3 December 2020

File No: 2020/517034
Our Ref: R/2020/6/A

Response to EIS – Waterloo OSD – SSD 10437, 10438, 10439, 10440 and 10441

Sheet title
General Arrangement Plan
Level 16-22 Plan

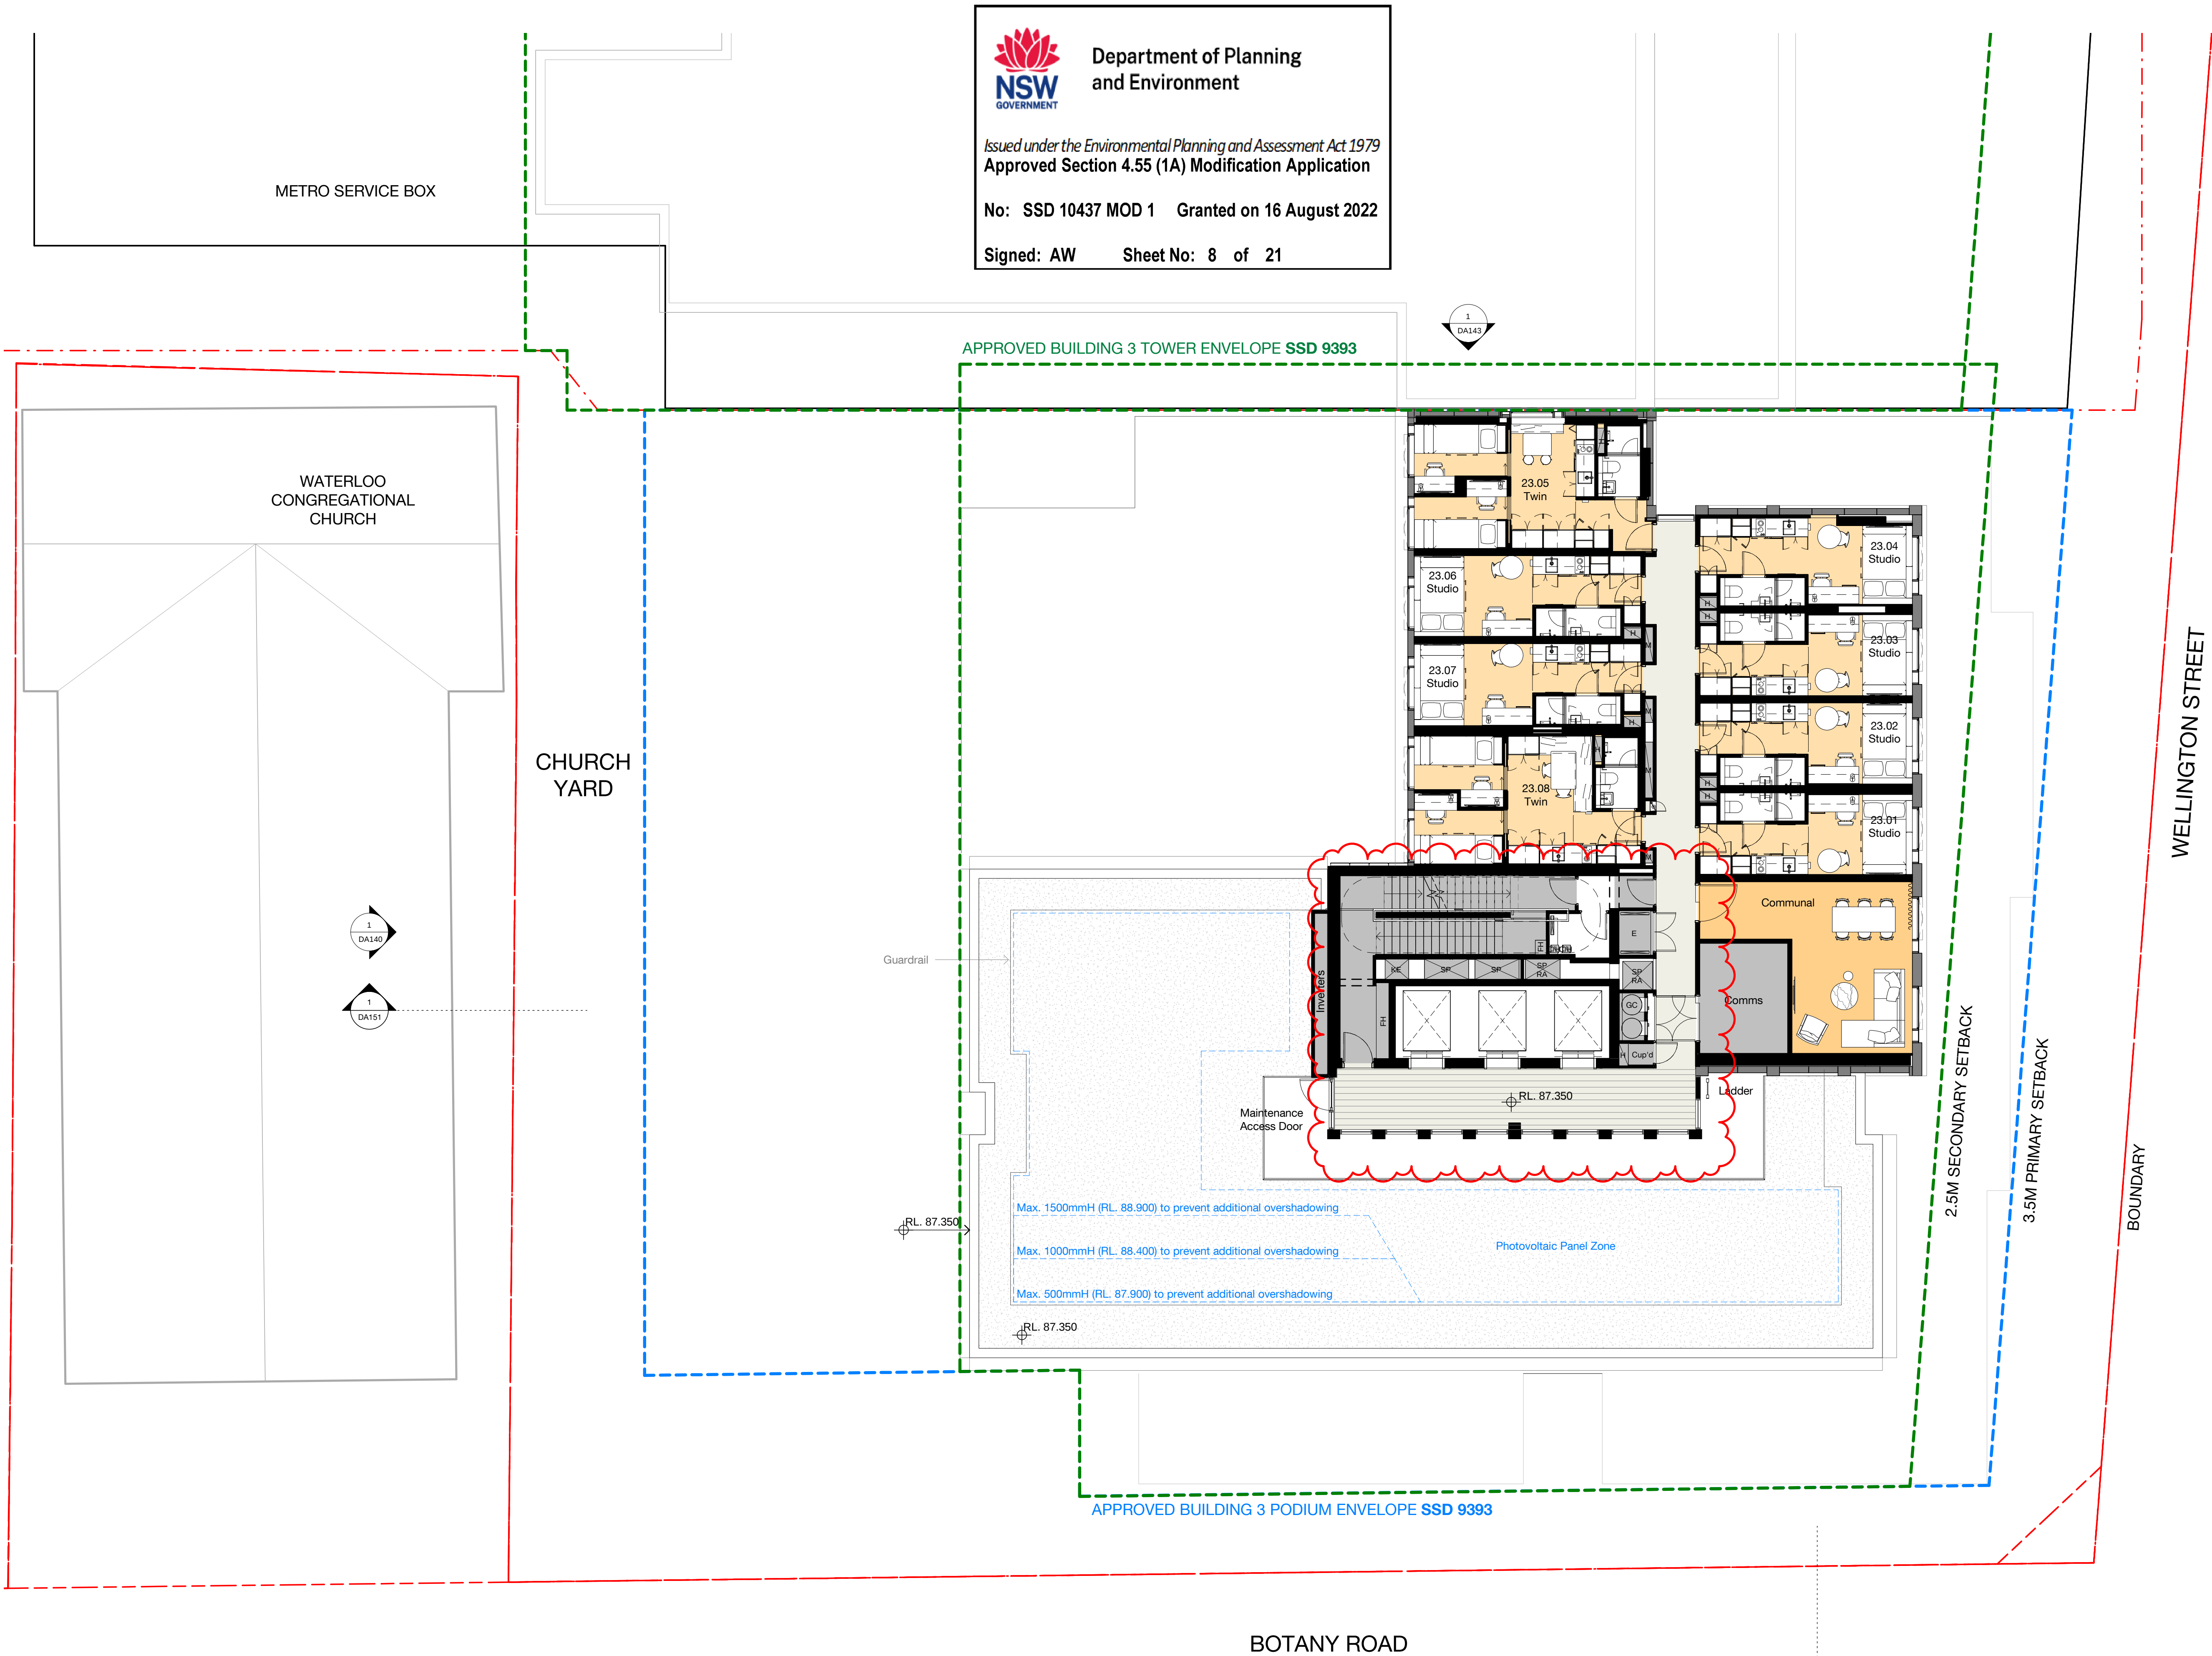
22. Private open space – 3-bedroom apartment balconies have less than the minimum 2.4m width (see apartment AXX05 on levels 20-21) as approximately 2 metres is provided. Insufficient room is provided to cater for furniture placement for the larger apartment and to allow space for other activities, contrary to Objective 4E-1 of the ADG.

General Arrangement Plan
Level 24 (Plant) Plan

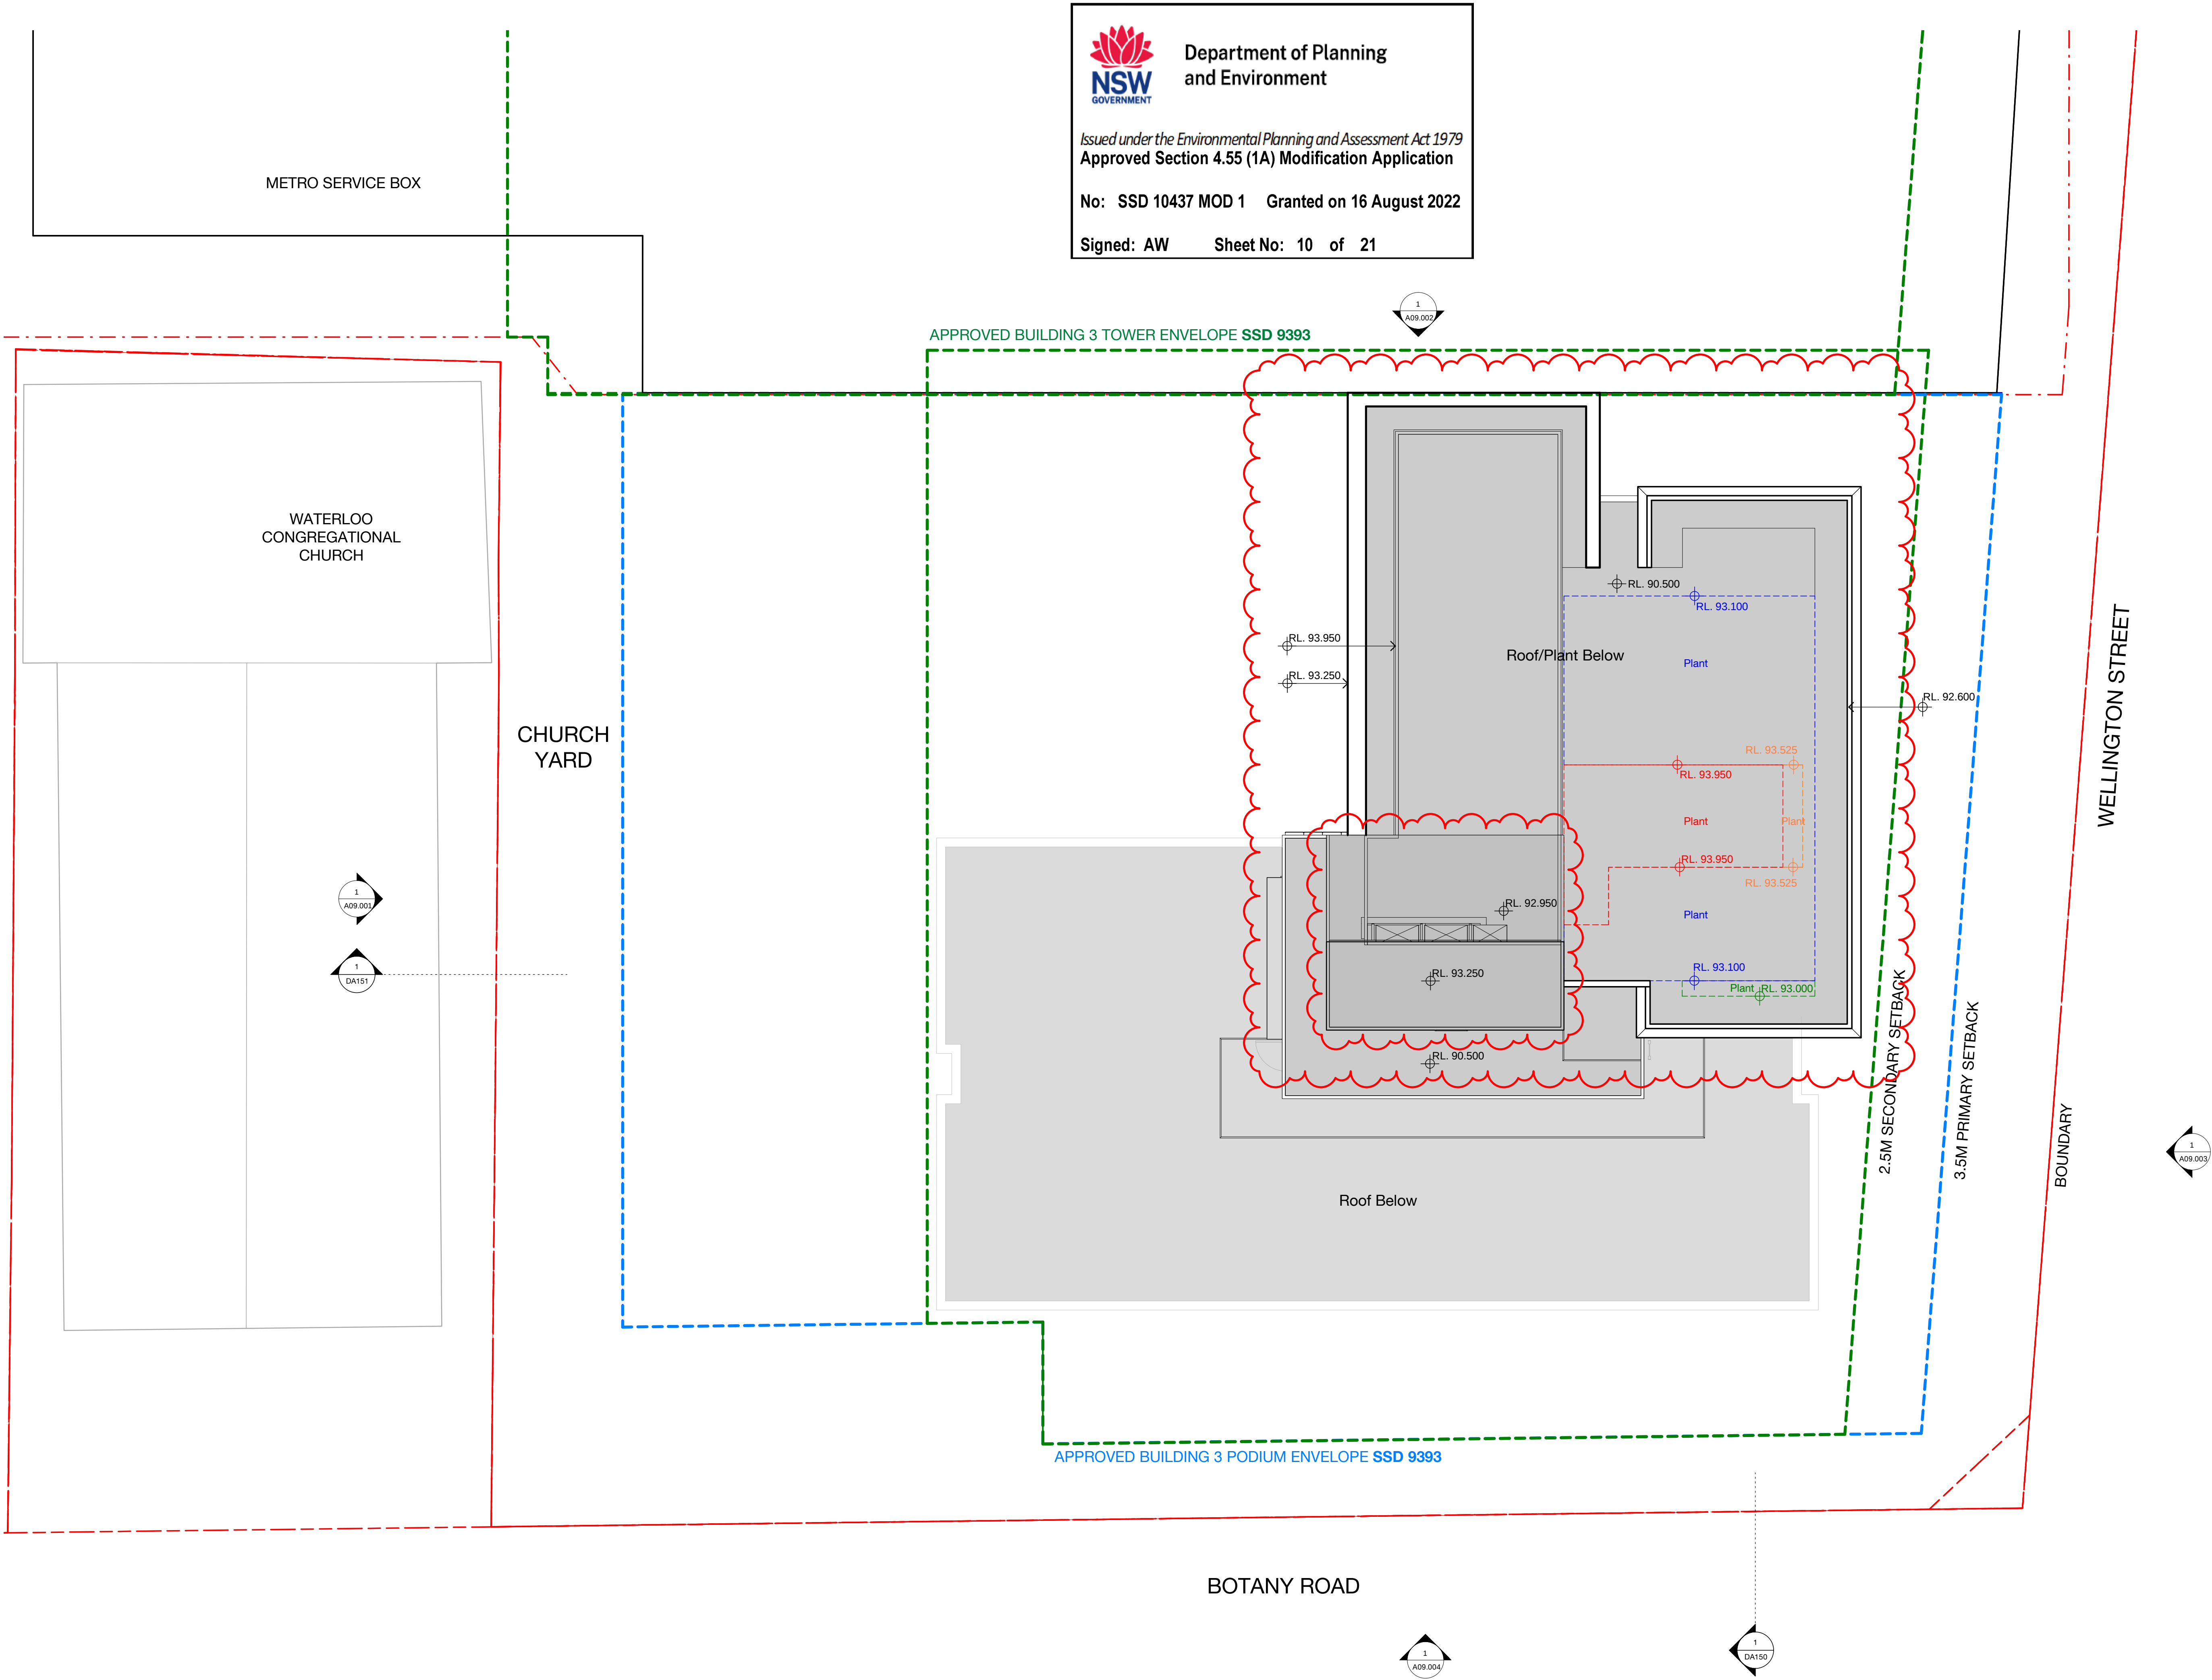
- (g) A large consolidated plant room is provided on Level 24, which is supported as this removes the need for ad-hoc equipment on the adjoining areas of roof. A condition of consent is recommended to require the integration of all roof services within the Level 24 plant room and to prohibit the installation of any roof plant on any other areas of the roof.
